DRB CASE ACTION LOG (PREL & FINAL)

DRB Application No.: 06DRB-00127 (P&F)

Project # 1004670

Project Name: LANDS OF TIJERAS PLACE IMPROVEMENTS

LOT 3-A-1

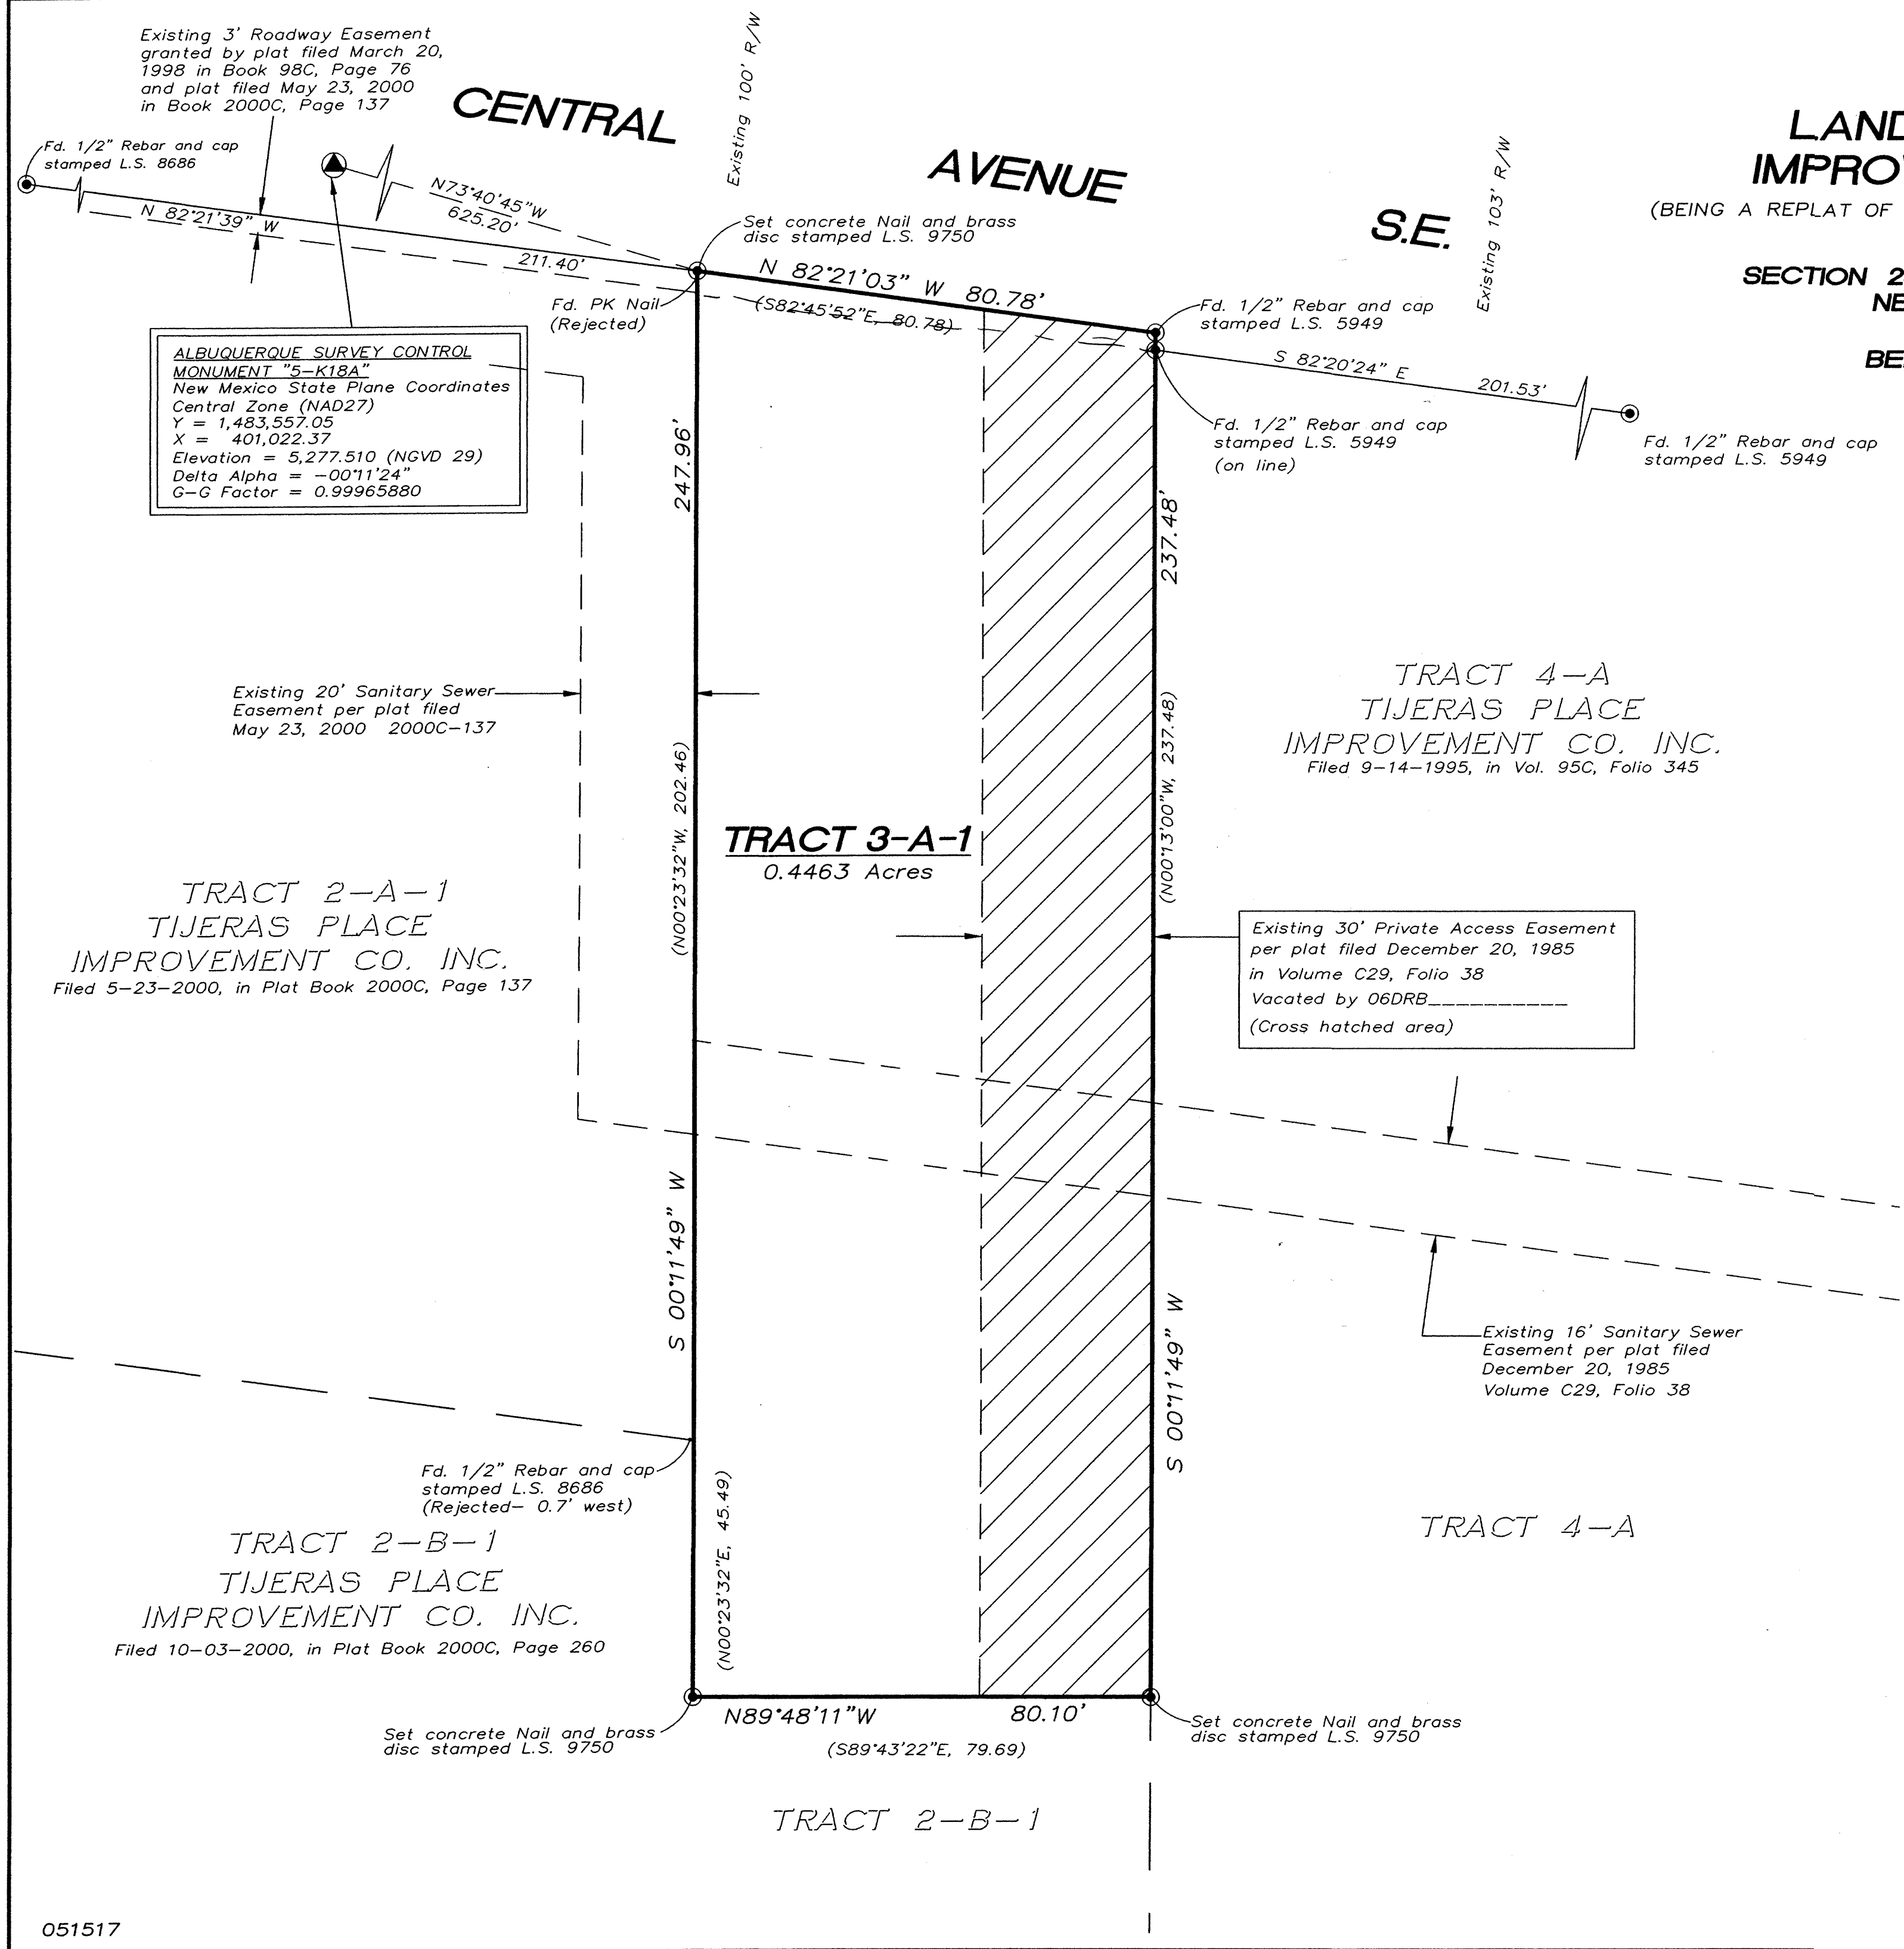
TRANSPORTATION: 3 foot public roadway easement or right of way dedication.

At the February 8, 2006, Development Review Board meeting, the preliminary and final plat was approved with final sign off delegated to Transportation Development for 3-foot public right-of-way or a 3-foot right-of-way dedication along Central to be granted by the plat and to Planning for the AGIS dxf file and to record the plat.
